Our ref: DOC20/439551  
Senders ref: SSD-6687

**Uungula Wind Farm – exhibition**

Thank you for your email dated 22 May 2020 to the Biodiversity and Conservation Division (BCD) inviting comments on the Environmental Impact Statement (EIS) for the Uungula Wind Farm.

BCD has reviewed the EIS, Biodiversity Assessment Report (BAR), Aboriginal Cultural Heritage Assessment (ACHA) and associated documents.

Figure 3.1: Development Footprint mapped vegetation type

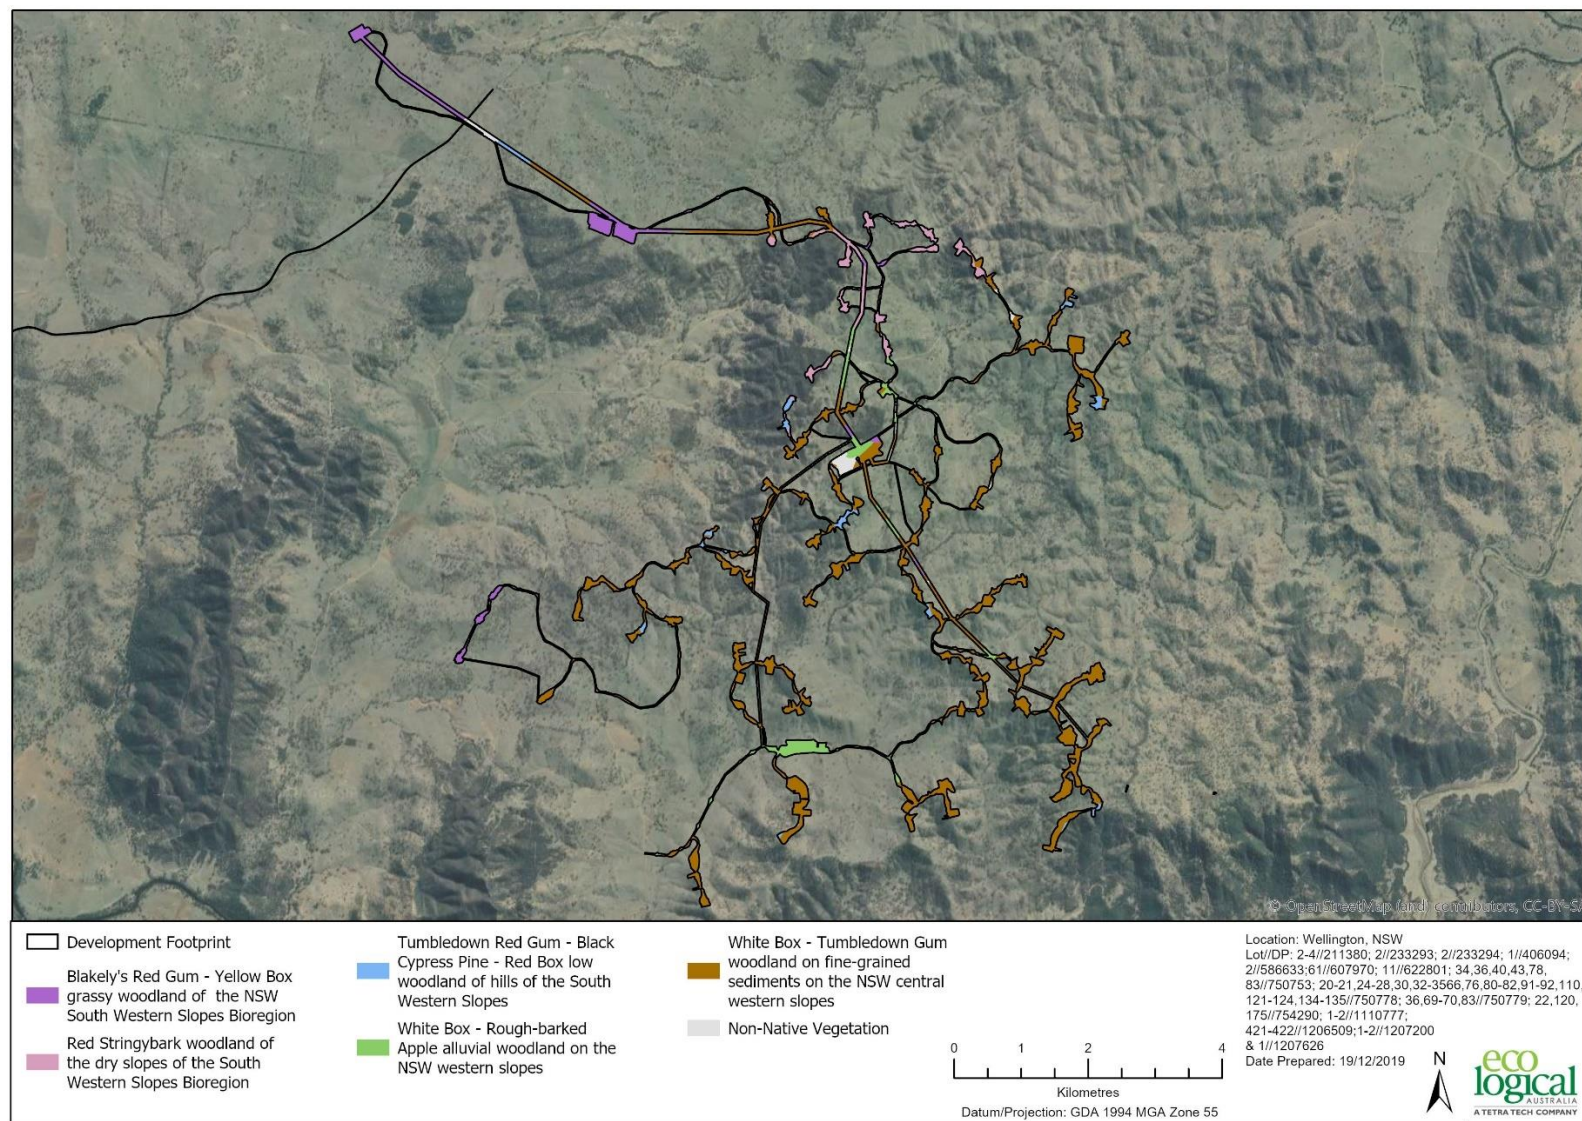
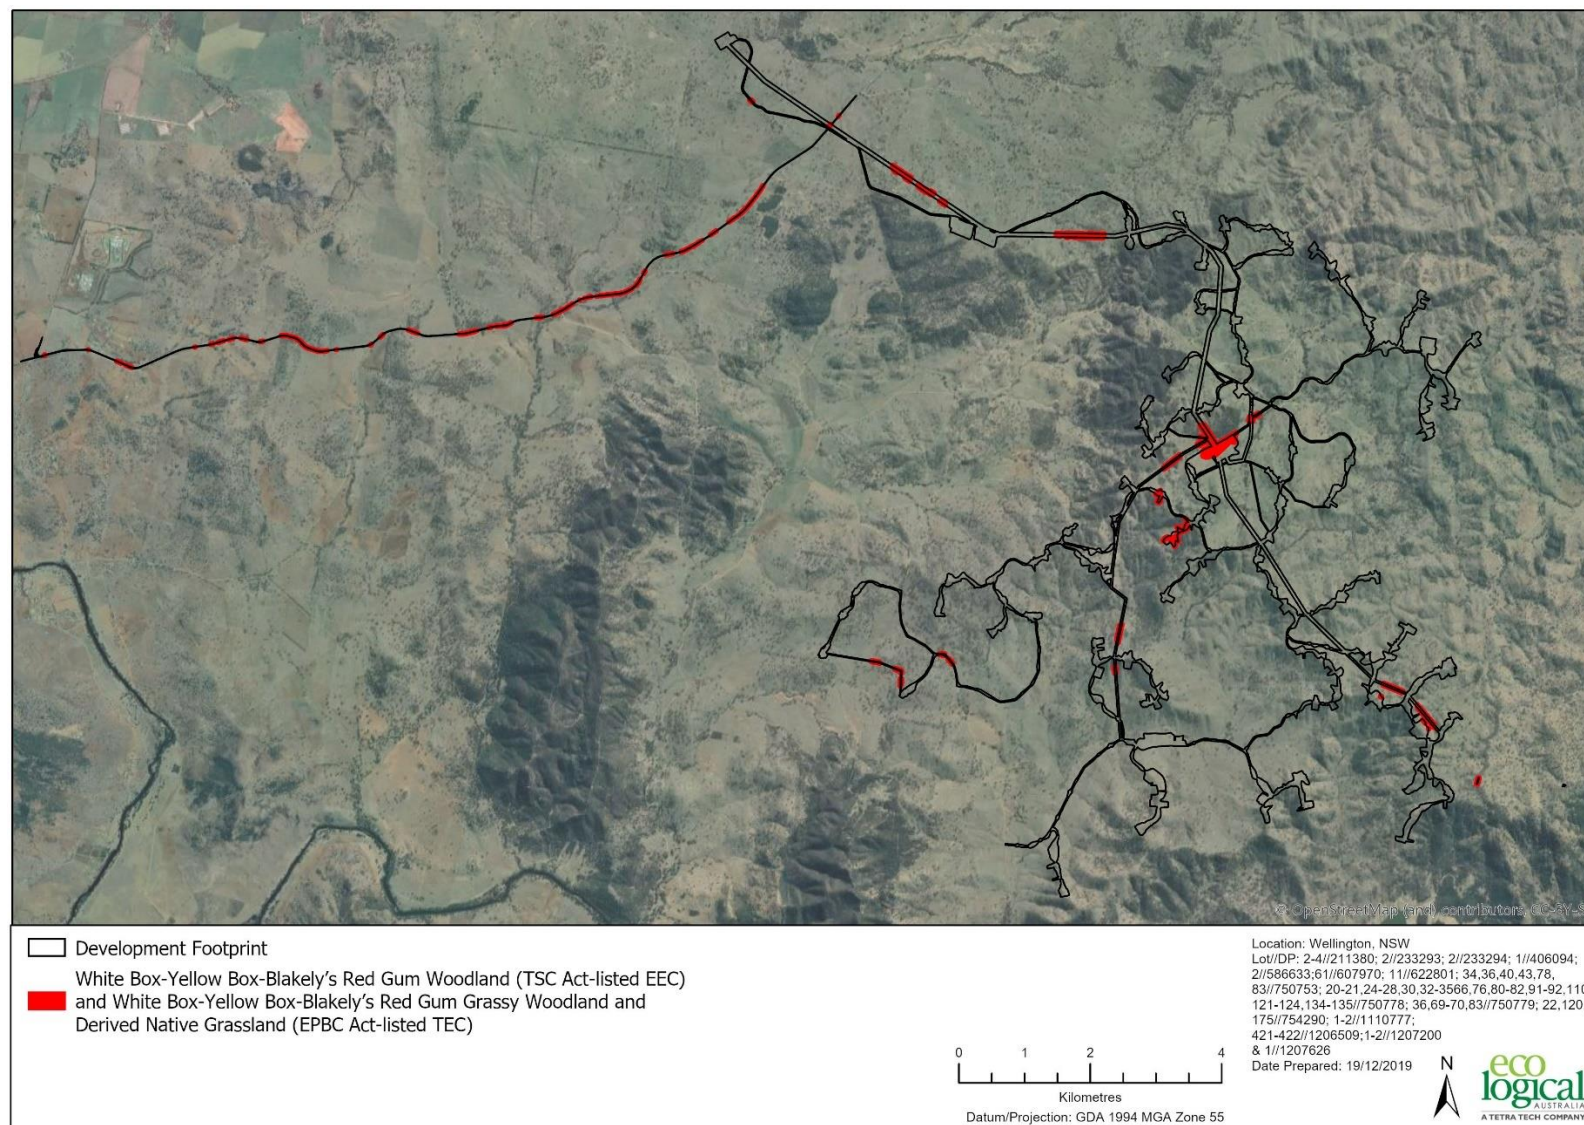
The BAR should be updated to include justifications for PCT selection, comparison of vegetation zones against the identified PCT, the description of differences between condition types of a PCT and comparison of PCTs against TECs. While it is noted that much of the survey work was completed by ERM in an earlier study, this information is still required to be provided in this BAR. The BAR should be a standalone document and provide a transparent assessment of the biodiversity values of the Study Area.

The BAR would also benefit greatly with the provision of more detailed maps (of the scale comparable to the detailed maps provided in Appendix E). The maps provided in Sections 3 and 4, particularly those depicting vegetation mapping, are inadequate due to scale.

- 1.1 The BAR should address all the minimum requirements outlined in Table 20 of the FBA.
- 1.2 An additional Appendix containing detailed maps, at an appropriate scale, of PCTs, TECs, vegetation zones, plot and survey locations and species polygons be included in the BAR.
